ADDENDUM TO AVIATEQ INTERNATIONAL LIMITED REPORT (DECEMBER 2018)

Proposed Hornsea Three Offshore Wind Farm Addendum

Date: December 2018
By: Ray Reynolds / Alan Cuttler / Neil Mackay
Distribution:

Figure 3.9: Indicative Layout A with 300 turbines and 19 platforms.

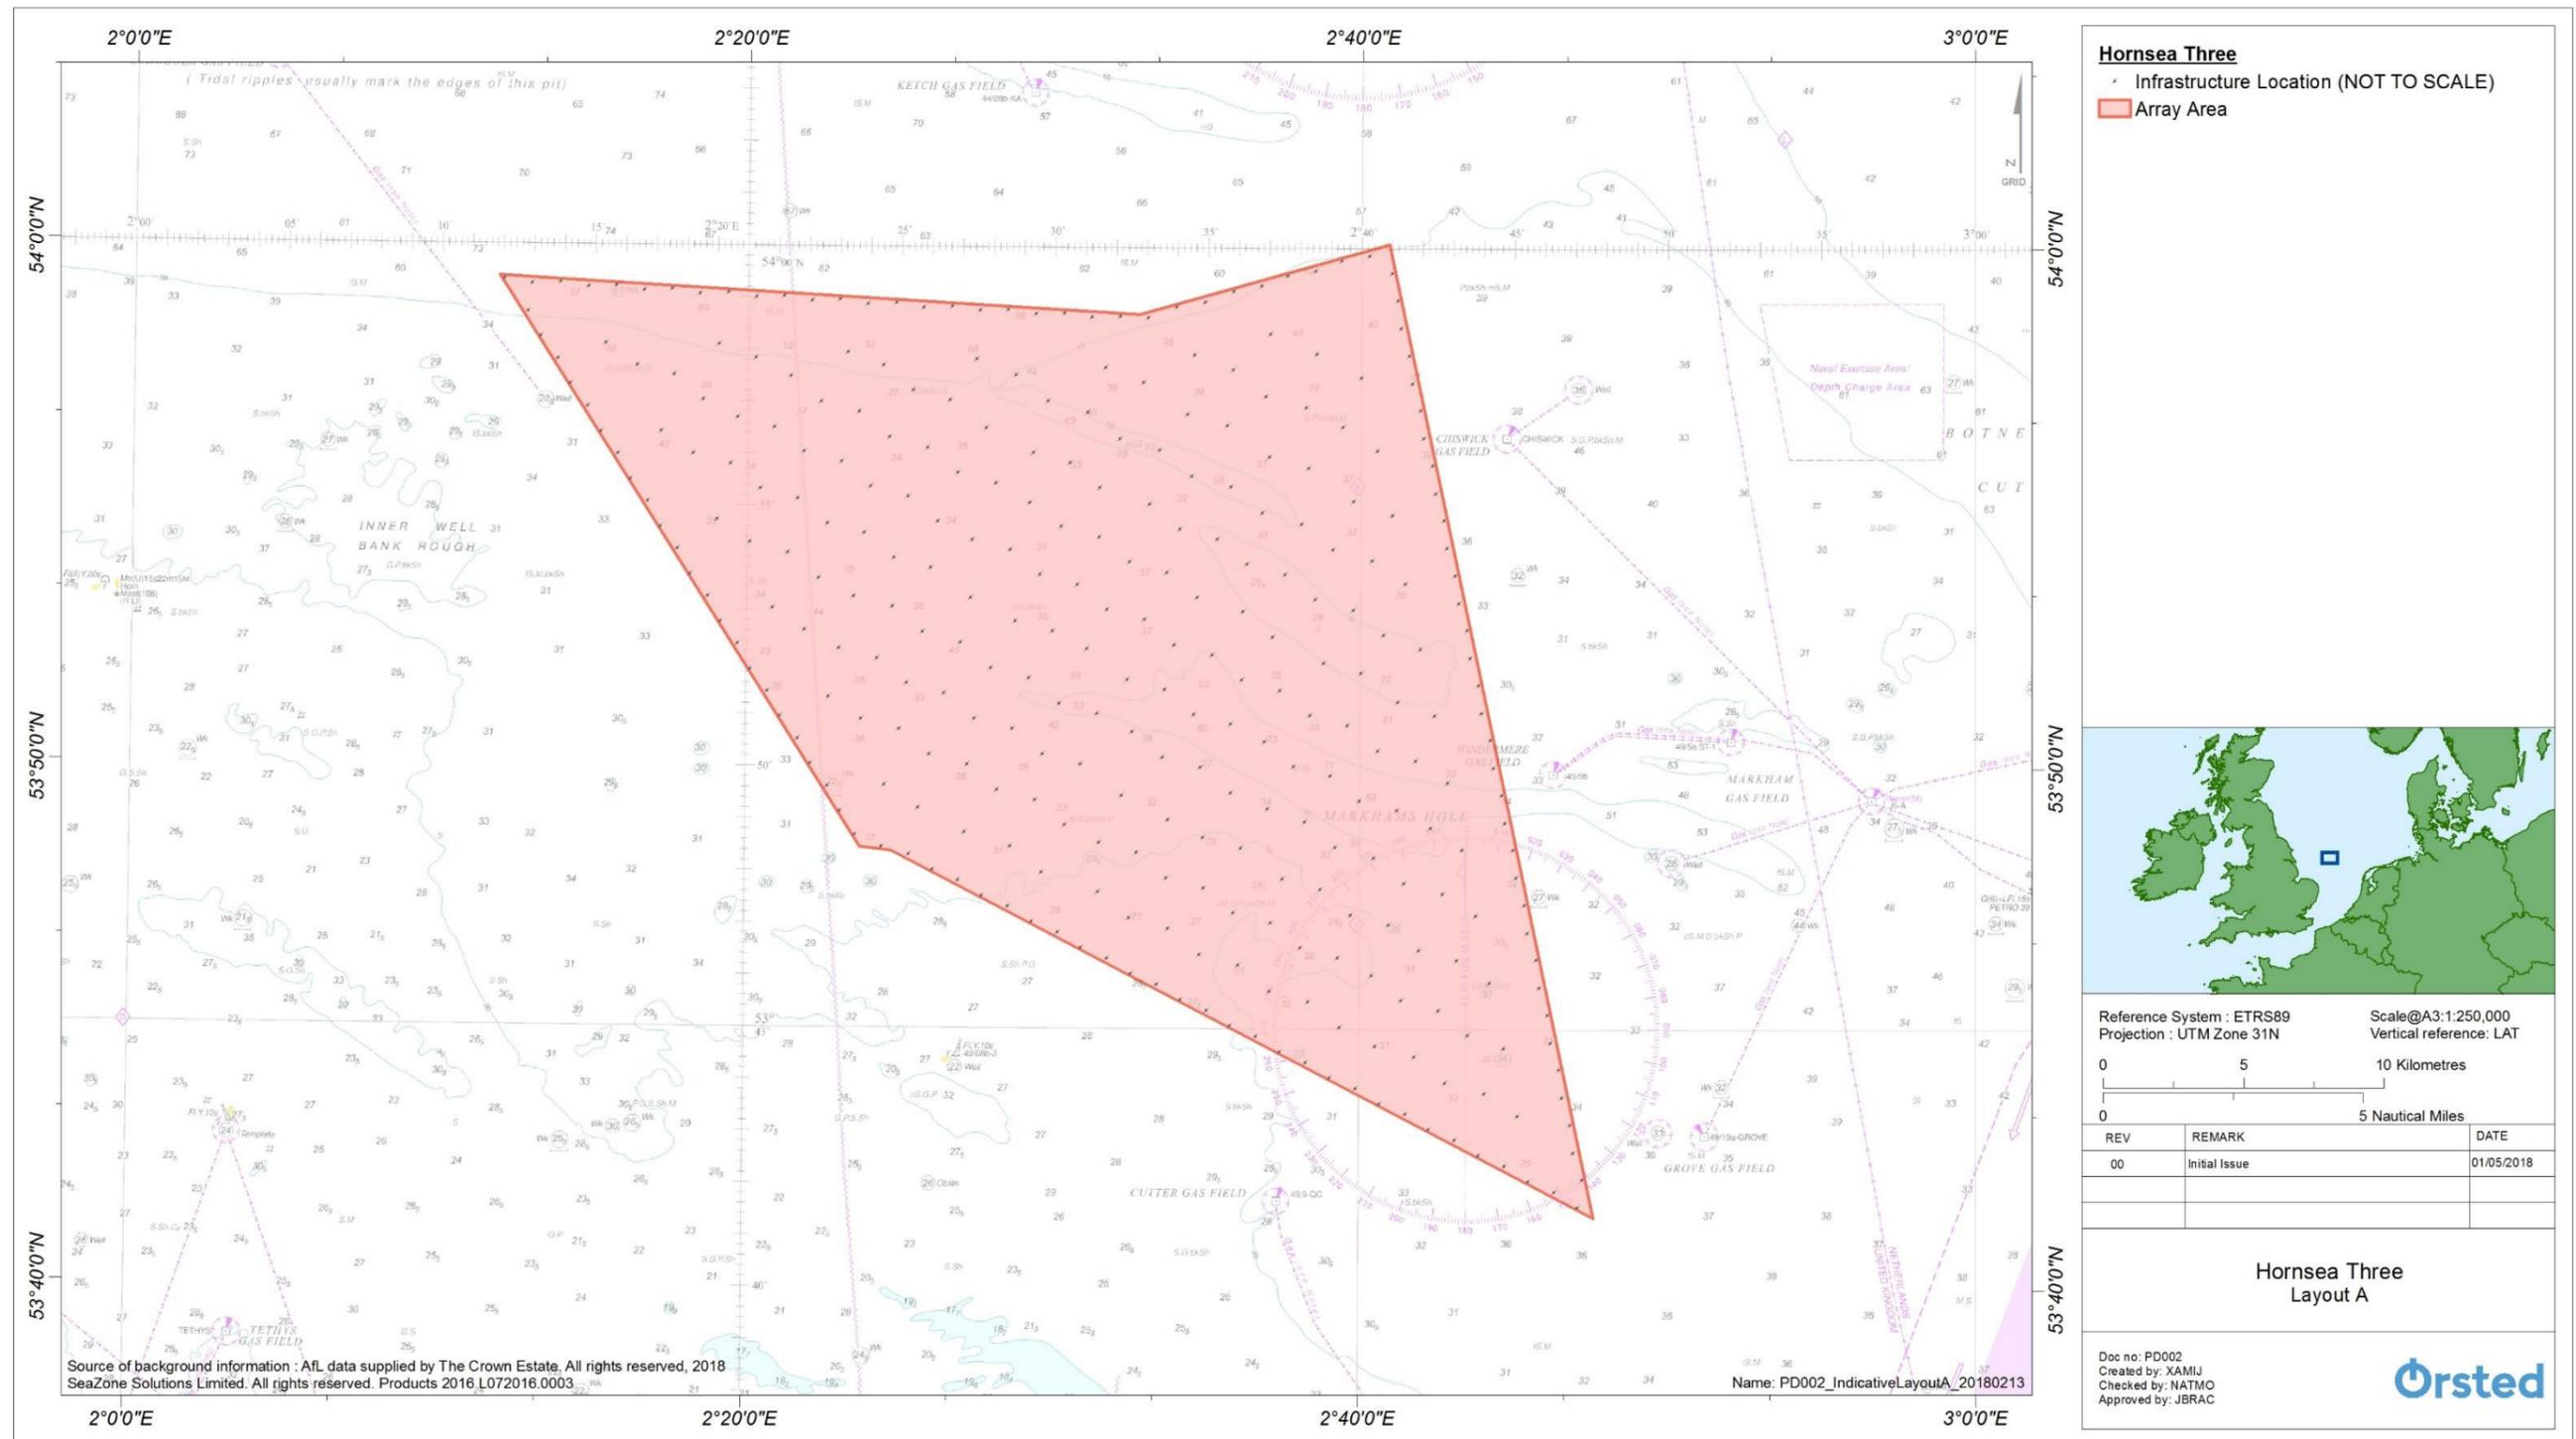
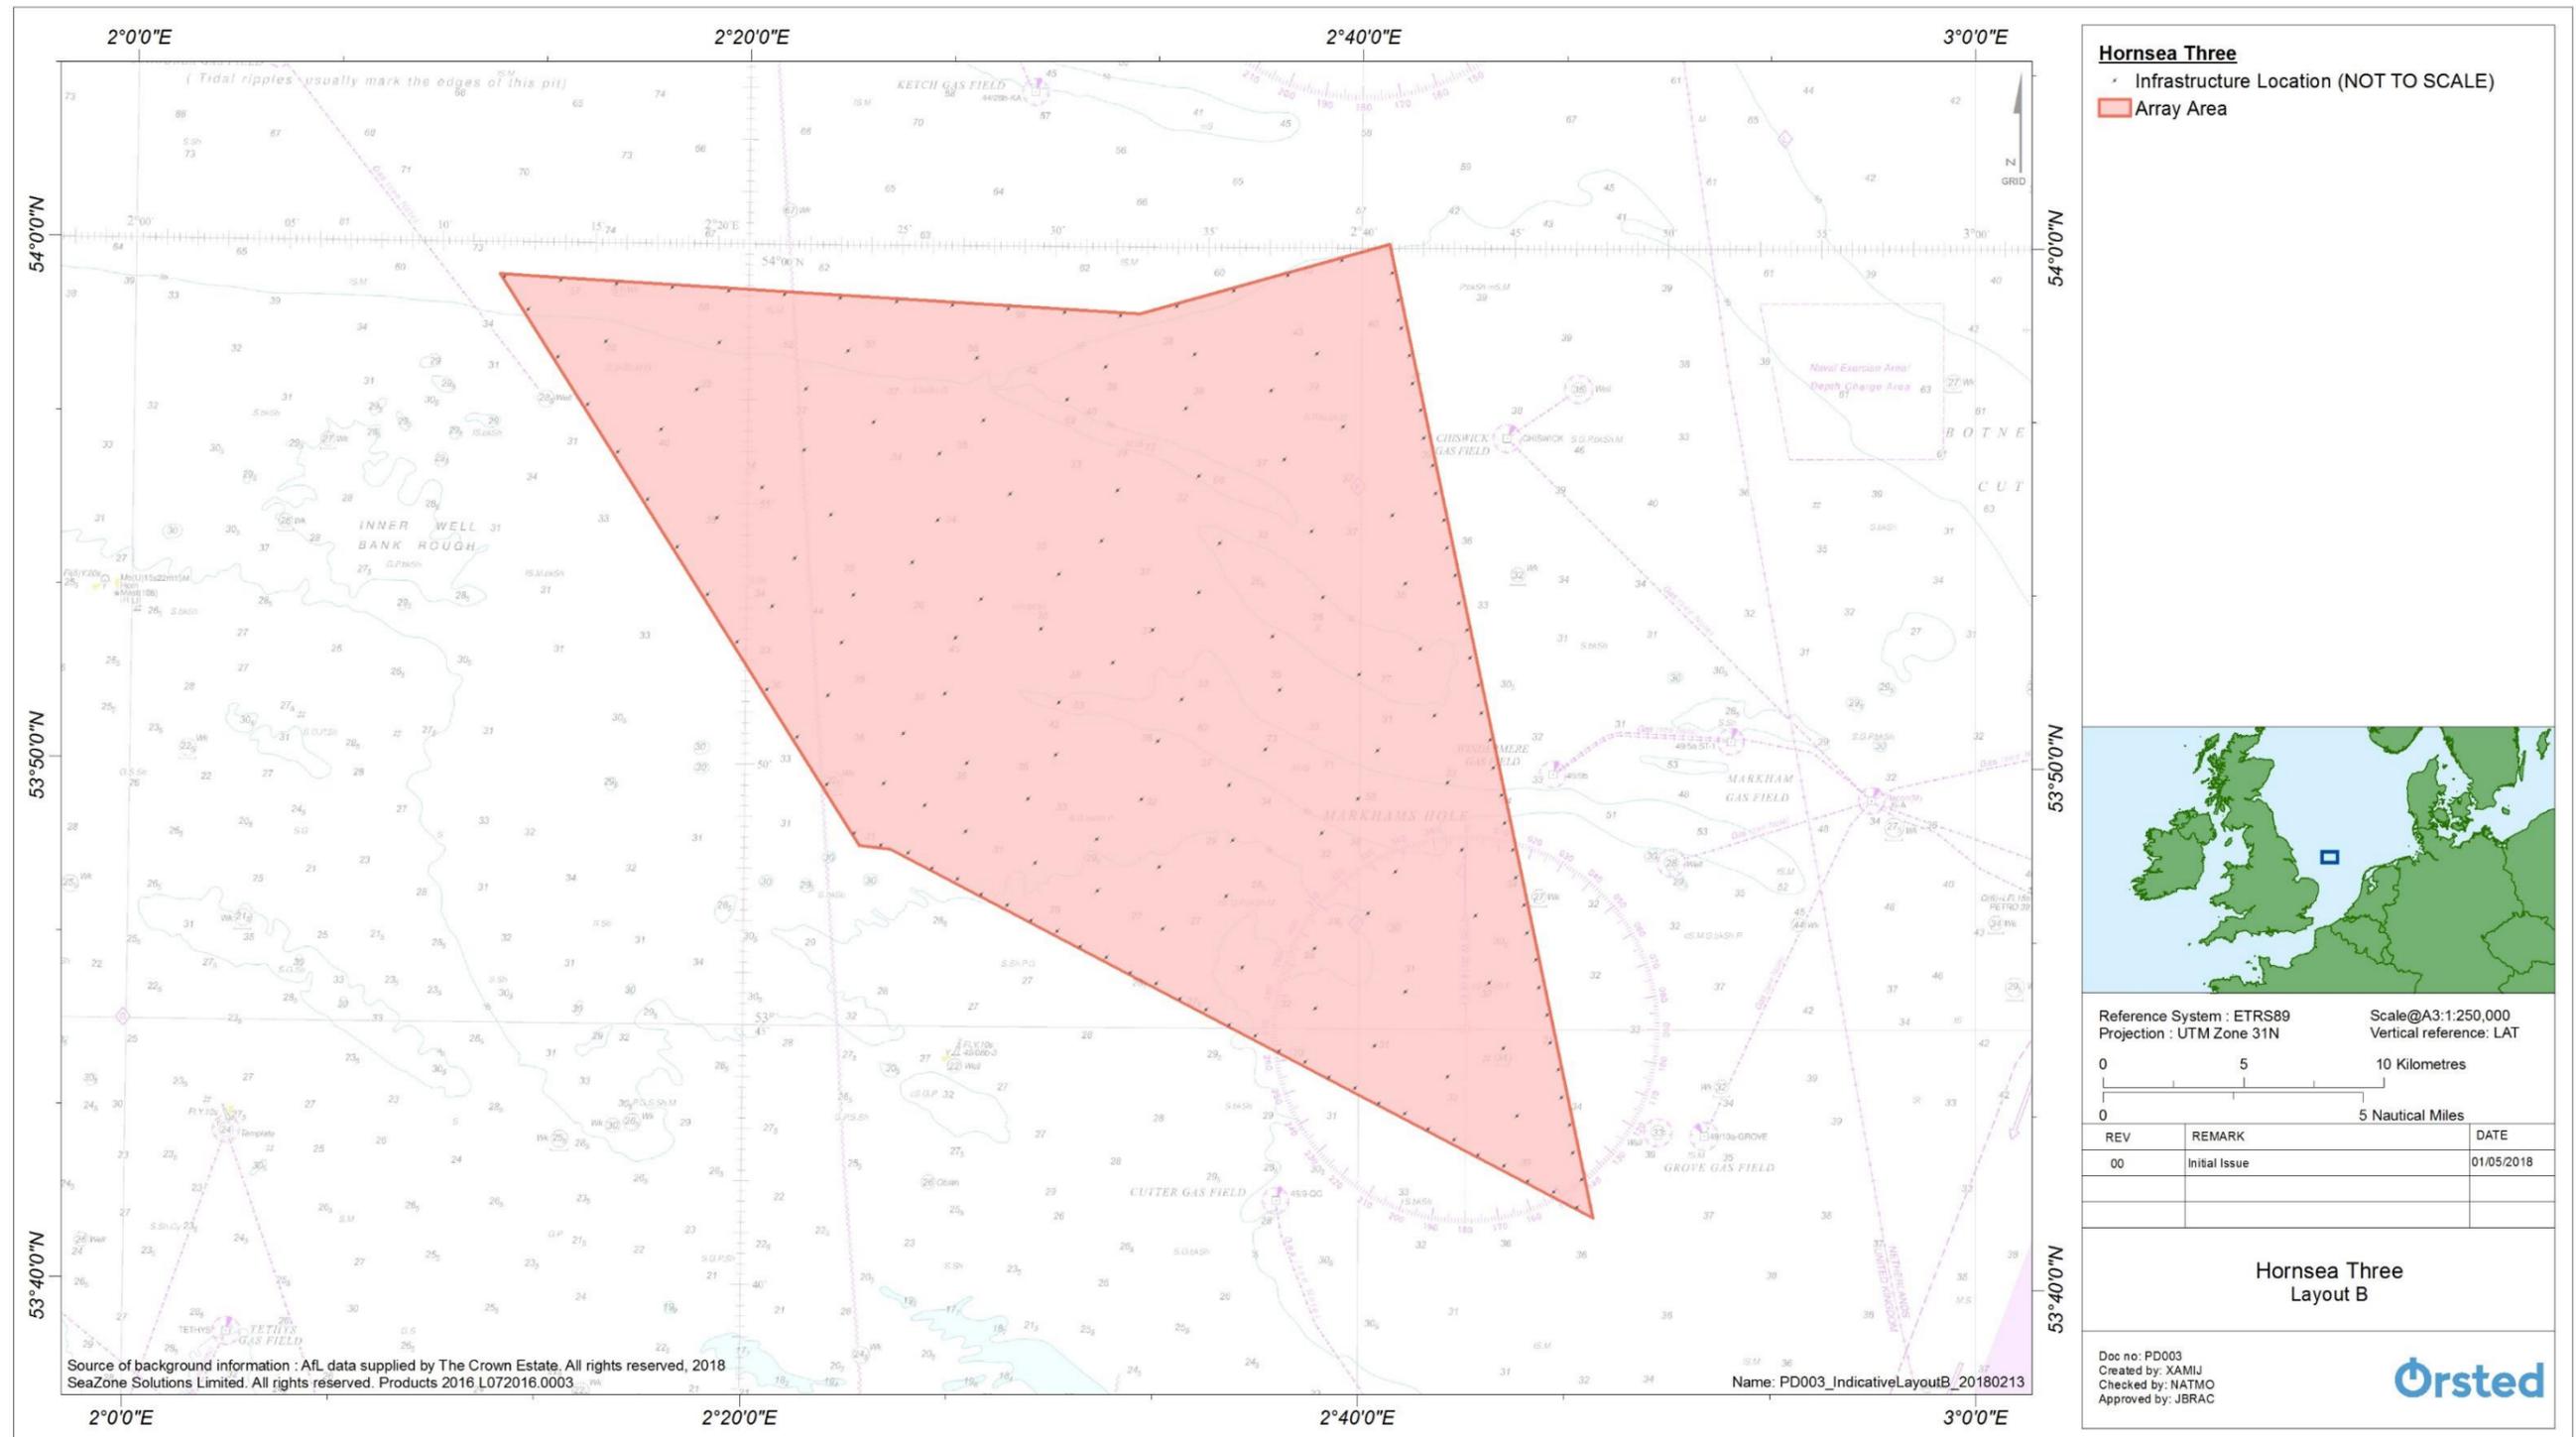
- 9.7 Indicative turbine Layouts A and B in Figures 3.9 and 3.10 of Environmental Statement Chapter 3, Project Description (PINS Reference A6.1.3) (May 2018) read with the diagram in Environmental Statement Figure 7.10 of Volume 5, Annex 8.1 (PINS Reference A6.5.8.1) (May 2018) shows the envisaged presence of obstacles in the area of the 7.0nm diameters areas around the Chiswick, Grove and J6A platforms. There is no guarantee that a helicopter could execute safely relevant manoeuvres in such areas around the Chiswick, Grove and J6A platforms. The ensured provision of the diameters (at the correct distance of 7.5nm) around each of the Chiswick, Grove and J6A platforms (illustrated in ES Figure 7.10 of Volume 5, Annex 8.1) would enable the necessary safe execution of required relevant OM manoeuvres by helicopters in relation to those platforms. These 7.5nm diameters would also be within the CAP 765 consultation zone of 9nm.
